FURTHER REPORT UPDATE

Application No: A/23/15/PL

Reason for the Update / Changes

Further representations, consultee responses and amended Highway Access plan received, plus update on Unilateral Undertaking.

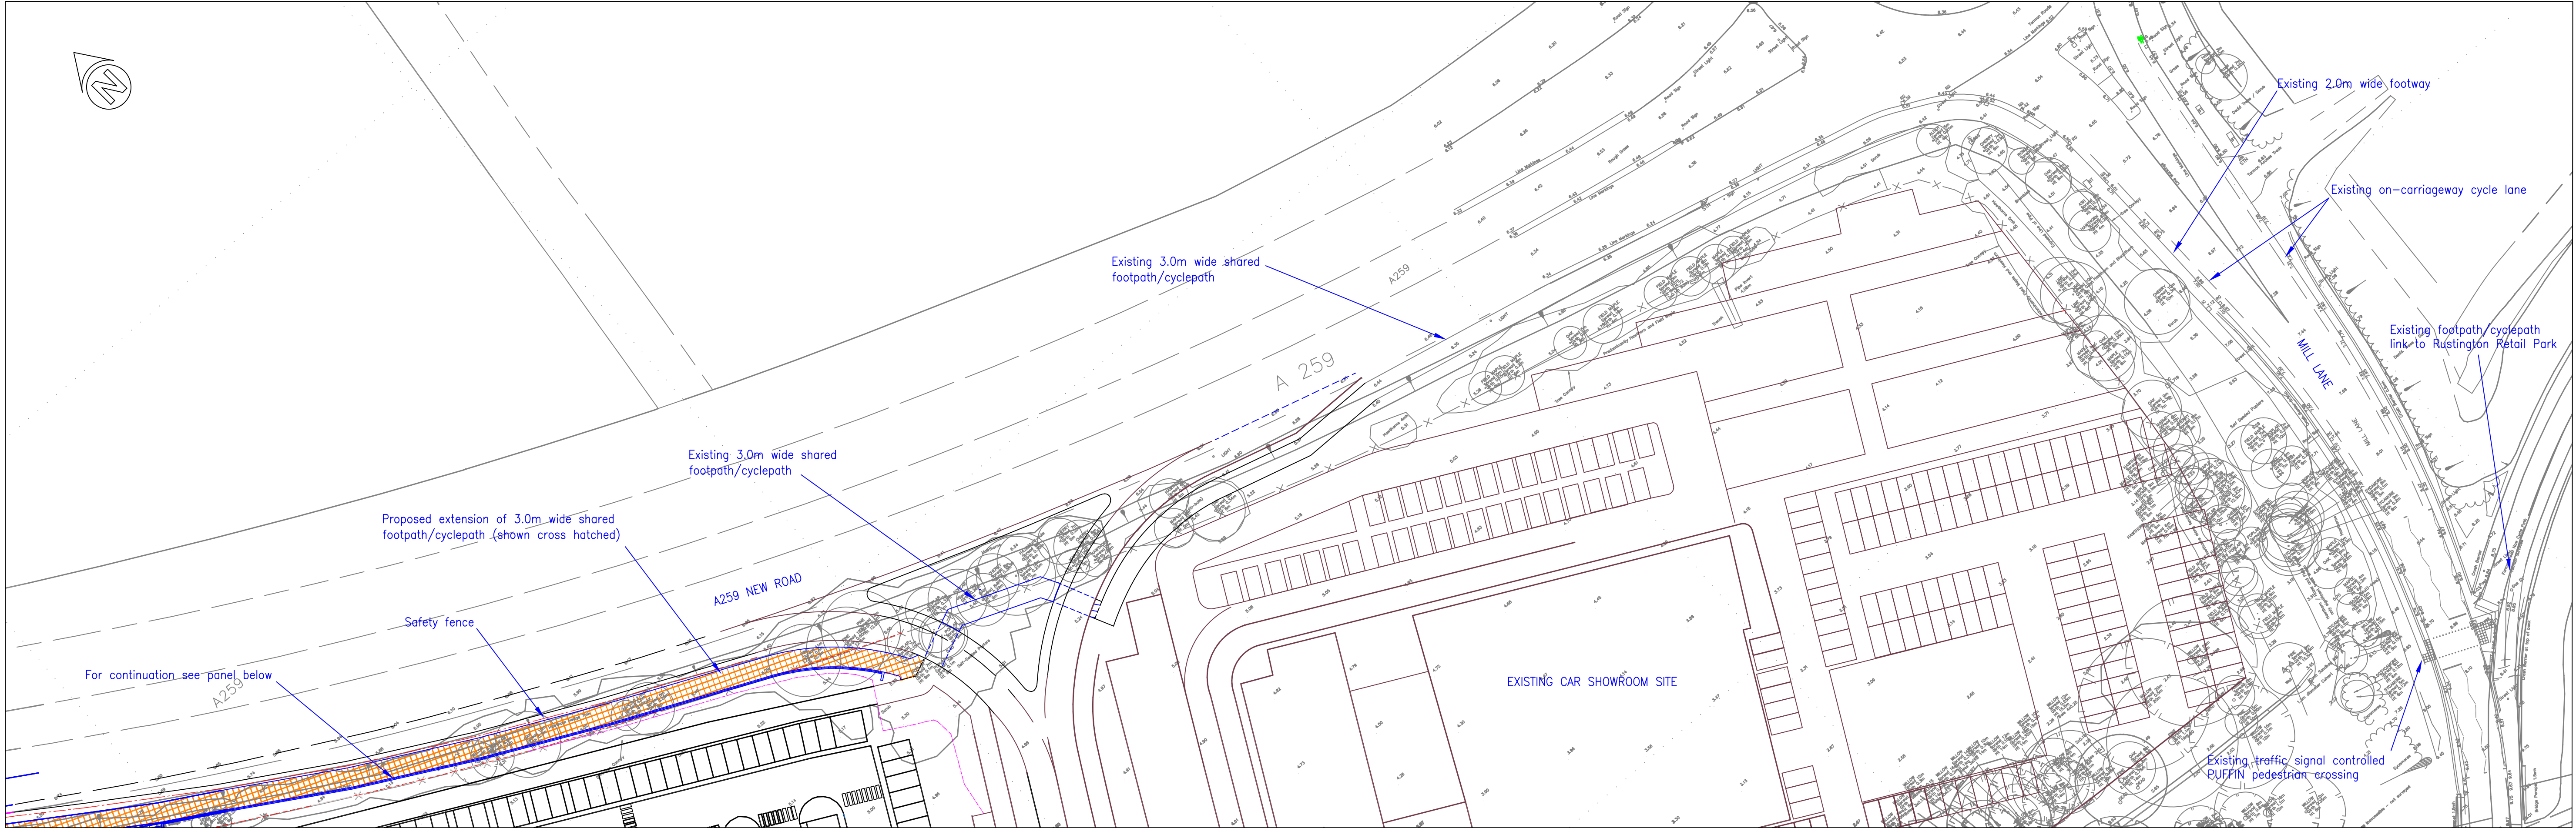
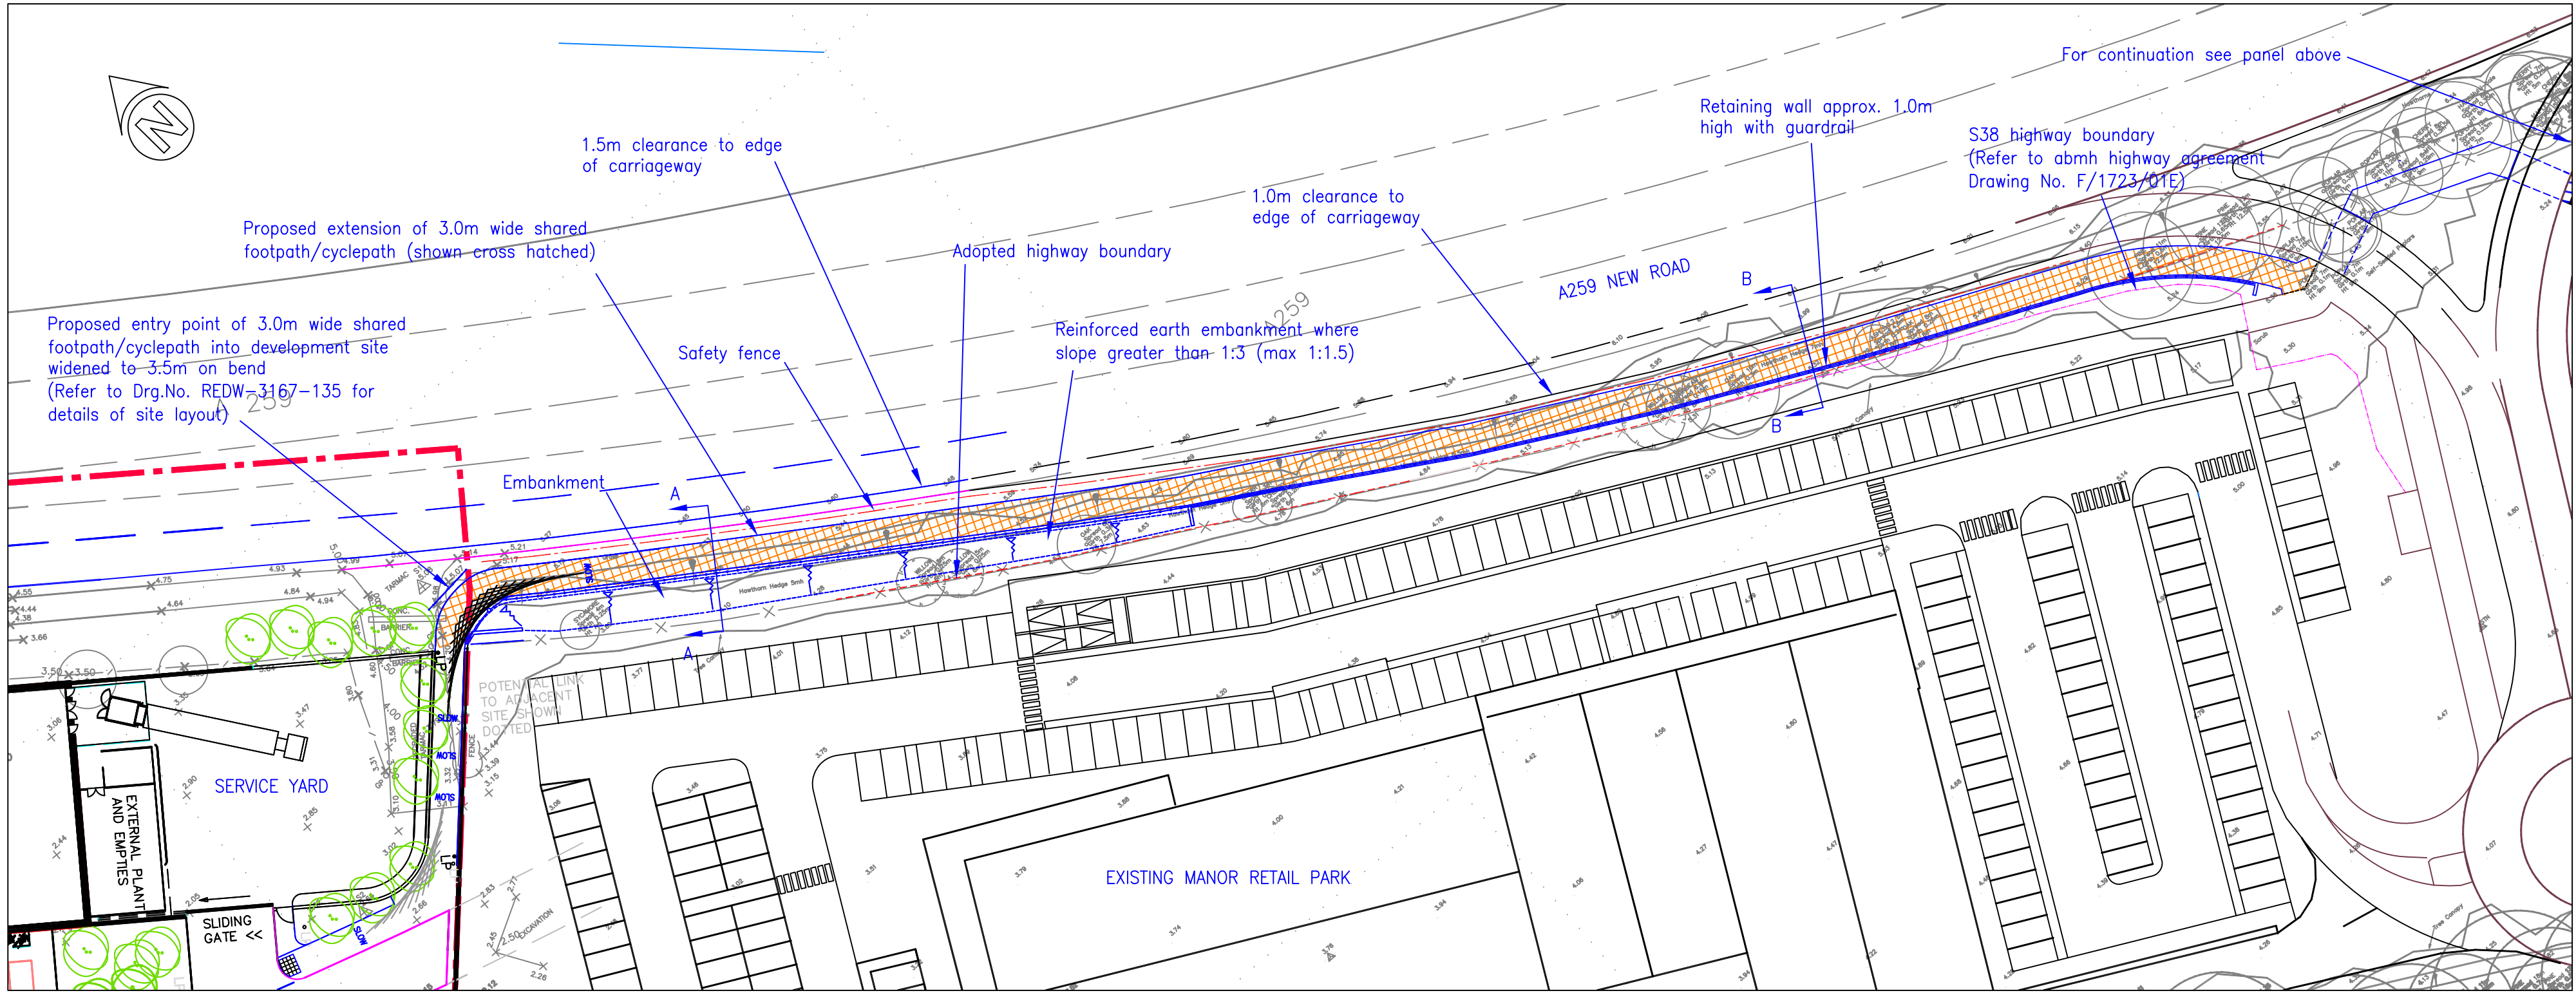
Comments received 18/09/18 on revised plan REDW-3167-137 seeking amendments to the design in relation to the radii differing from A/83/18/RES (23m as opposed to 30m) and amendment to visibility splays.

Comments received on further revised plan REDW-3167-138 confirm that it is acceptable.

A further revised access plan has been submitted (ref REDW-3167-138) to address the concerns raised by the Local Highway Authority in relation to the differing radii and visibility splays. The applicant has provided justification for the entry radii (which departs from the standard 20m) and added the visibility splays to the revised plan to demonstrate that they can be achieved. Therefore, the revised plan improves the compatibility of the access with A/83/18/RES and the conclusion on highway access remains unchanged.
